March 29, 2010

**Re: Minor Site Plan Review: 231 York Street; Demolition of existing building and construction of new building for restaurant use**

**Site Plan Application # 09-79900017**  
**CBL: 044-E-003-001**

231 YORK STREET PORTLAND, MAINE
 NORTH ELEVATION PROPOSAL
 1/4" = 1'-0" 3/8/10

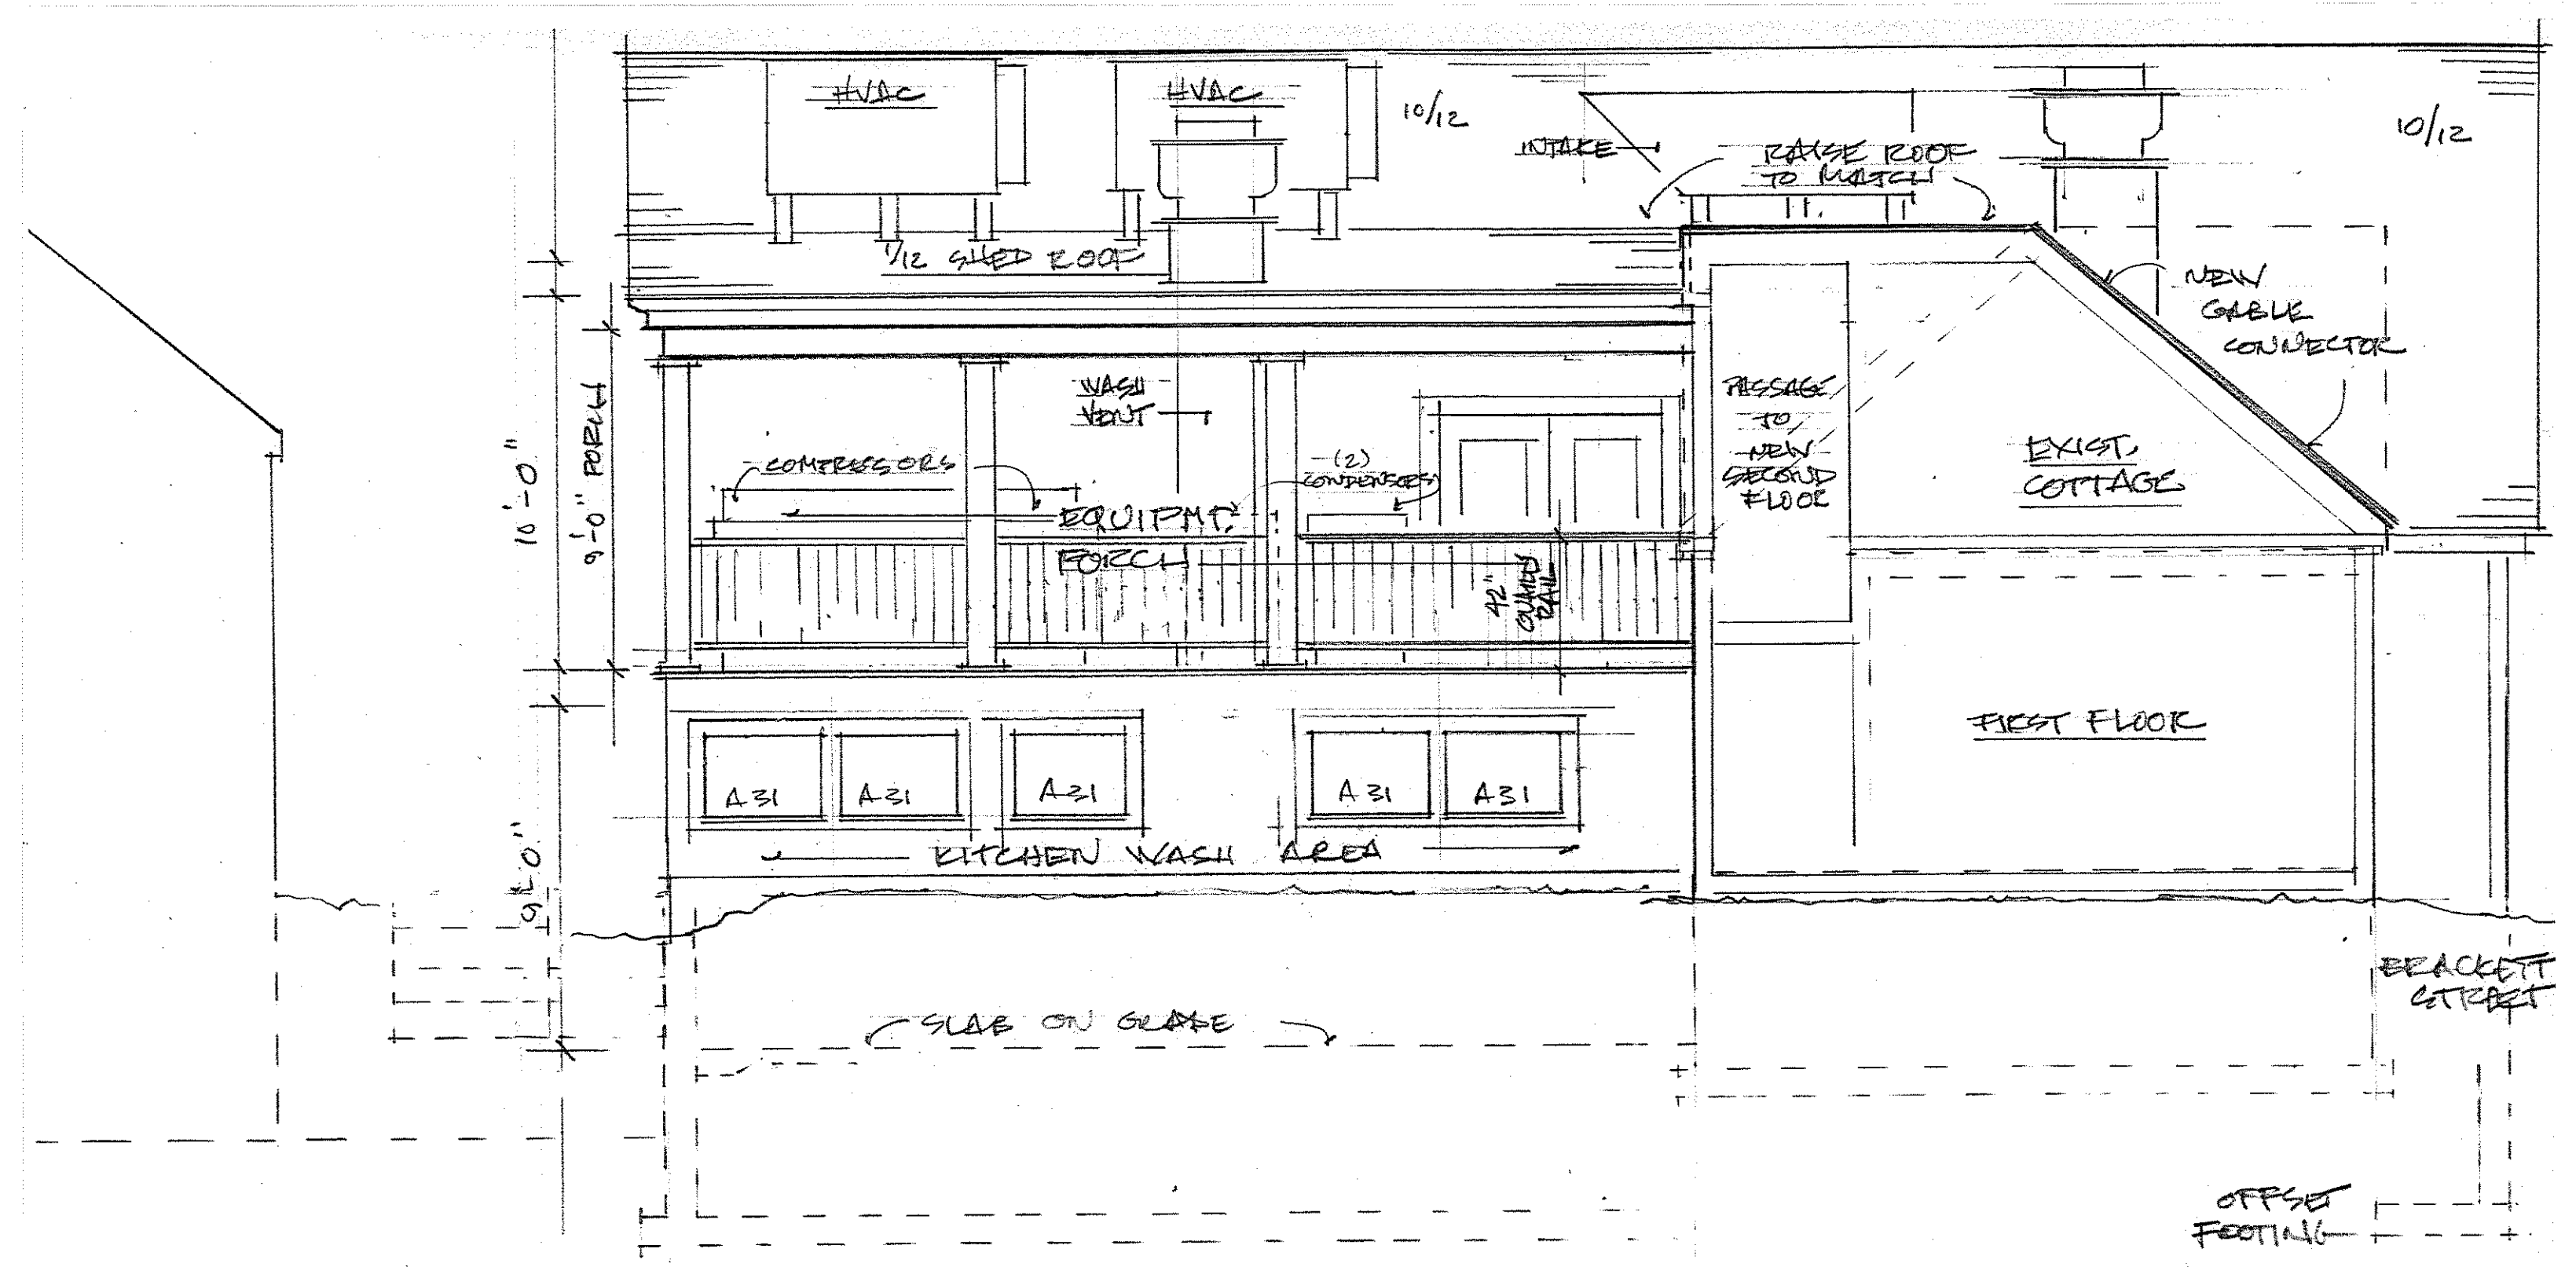
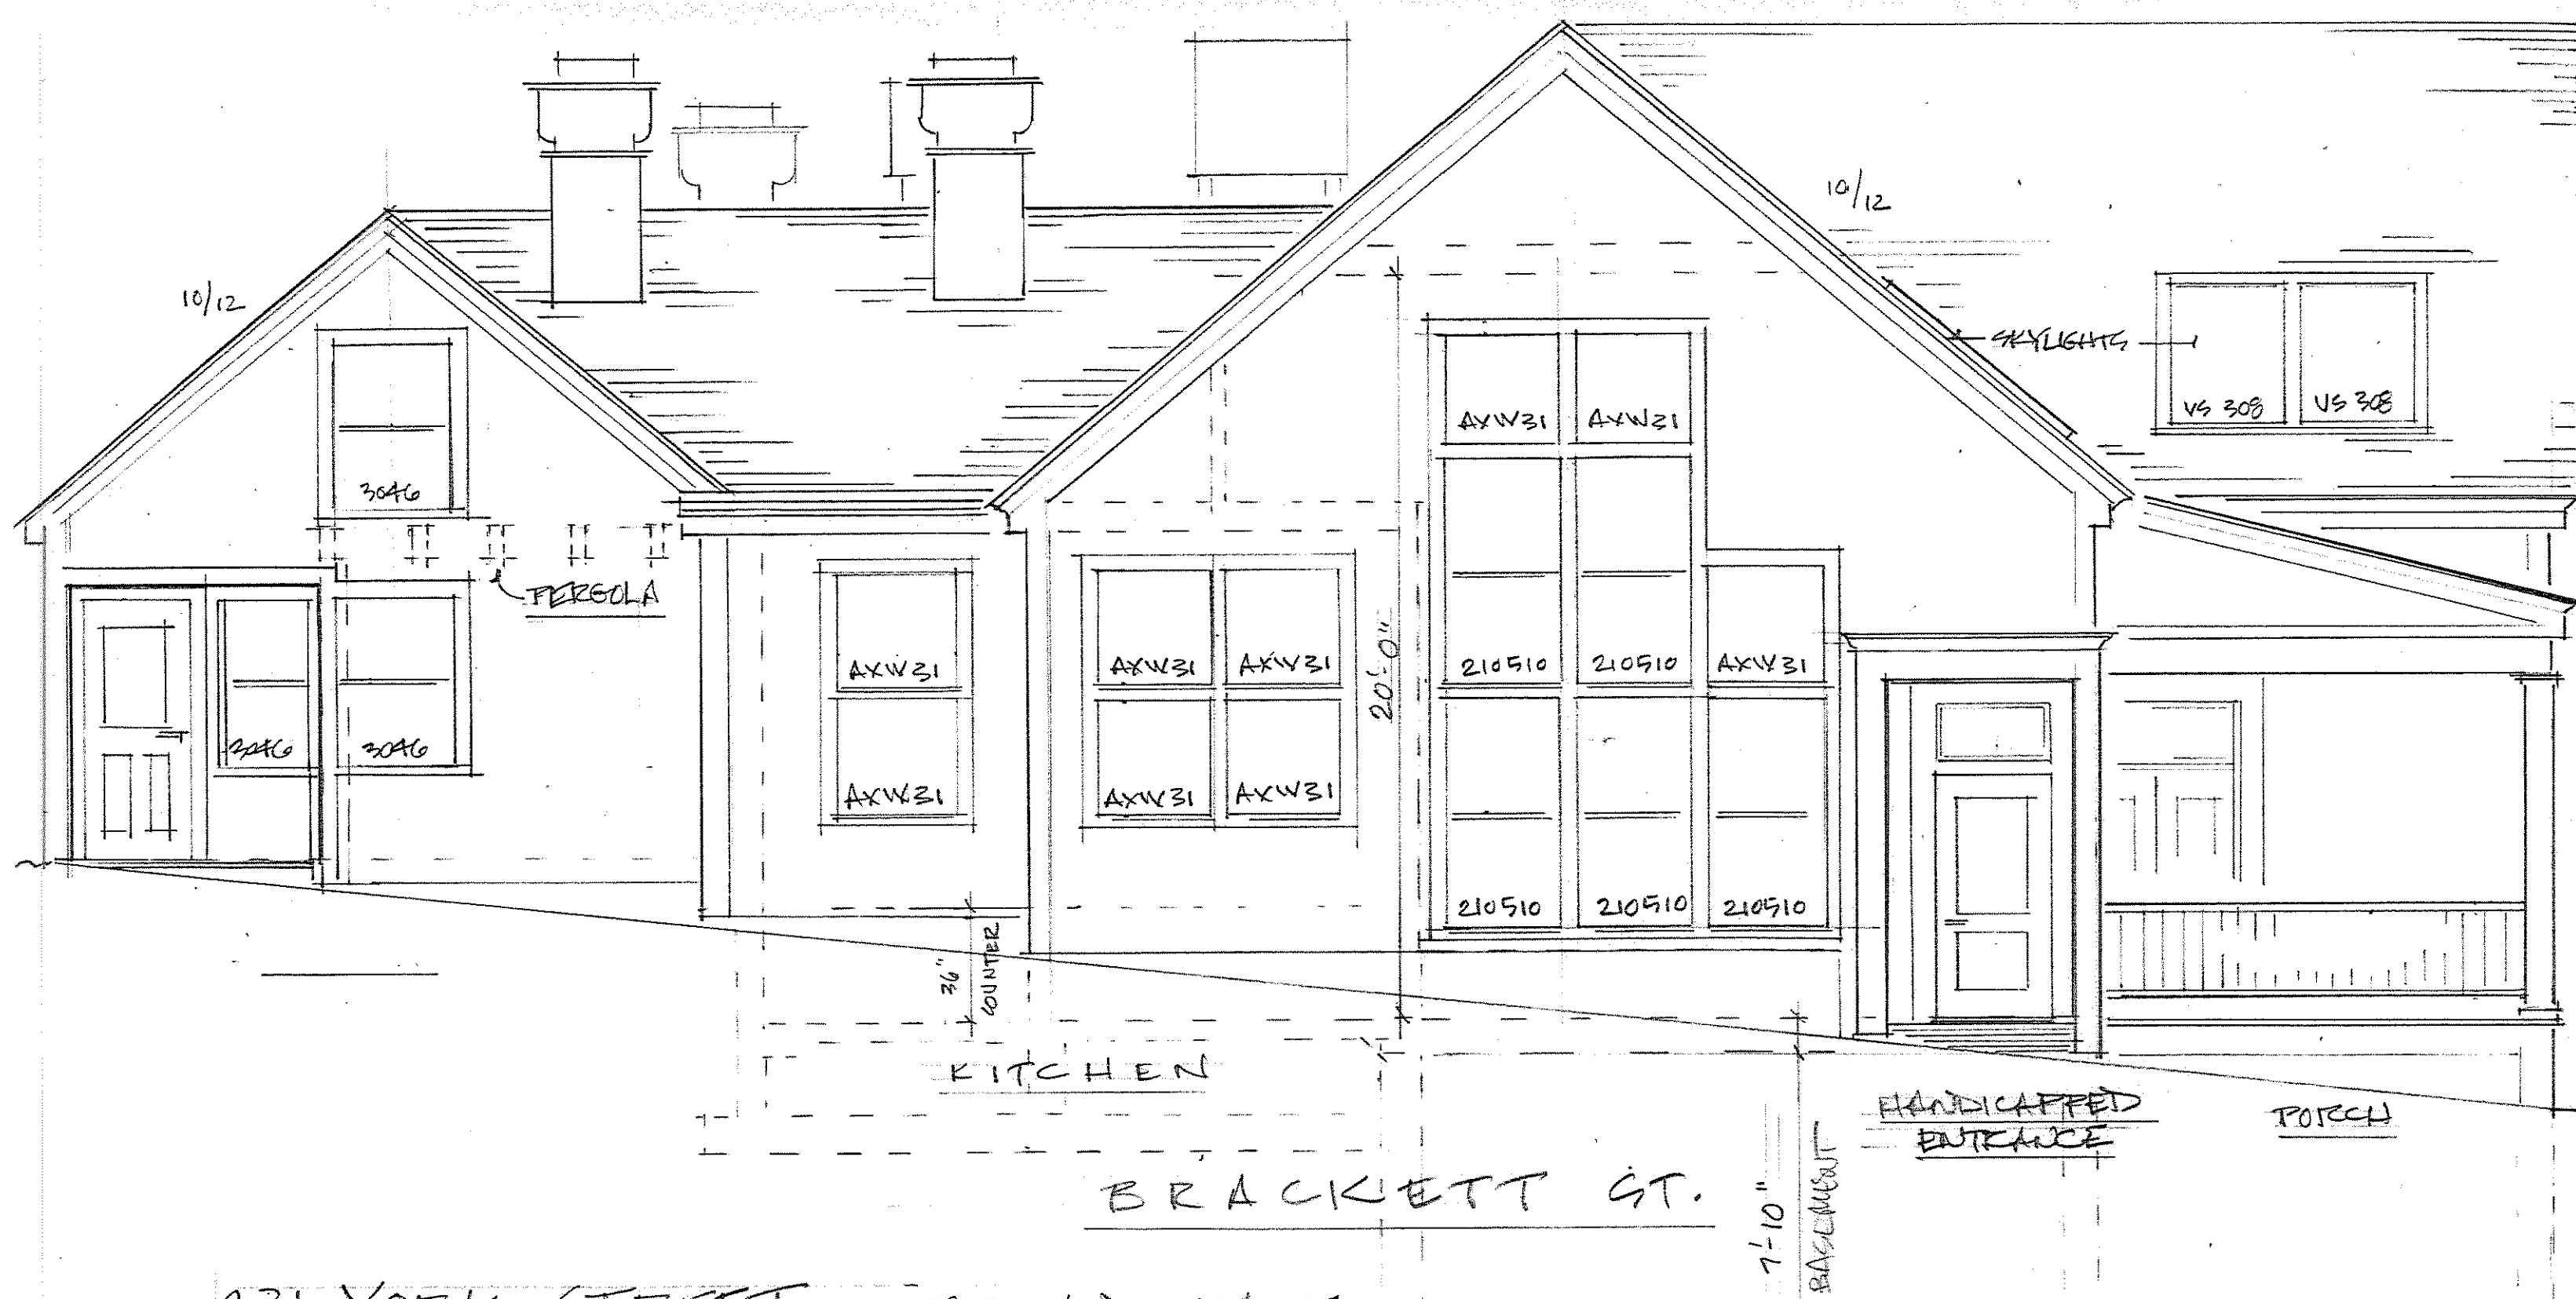
2. Zoning:  
Information regarding the rated noise levels and compliance with noise allowances is awaited.
3. Mechanical Plant:  
The set of plans submitted March 9<sup>th</sup>, 2010 are the first to show the proposed roof and porch mechanical plant (understood to be 4 vents and 2 HVAC units on the roof (all facing towards the residential neighbors) plus 2 condensers and some compressors on the rear-facing equipment porch. The City's ordinance is the context for the review and the B1 zone has a purpose statement that includes:

In summary, there are two issues related to the location, size and number of these units:

- a. **Noise:** The number of noise-generating roof and porch plant on the rear side of this building raises questions of the noise generated by each unit, the cumulative noise and the period of time over which they will be making a noise; and
- b. **Compatibility:** The B1 design standards require *"...commercial buildings shall be designed to be compatible with their residential and commercial neighbors... building scale, roof pitch, and fenestration shall be designed to complement surrounding residential structures."*

While we appreciate that this use does require some mechanicals, given that this is limited to 1000 sq ft we would like information/clarification regarding why so many are needed, why they need to be at this scale, and whether any could be relocated within the envelope of the building or on the side of the building. As requested, I confirm a meeting has been arranged to discuss these questions on **Monday April 5<sup>th</sup>, 2pm.**
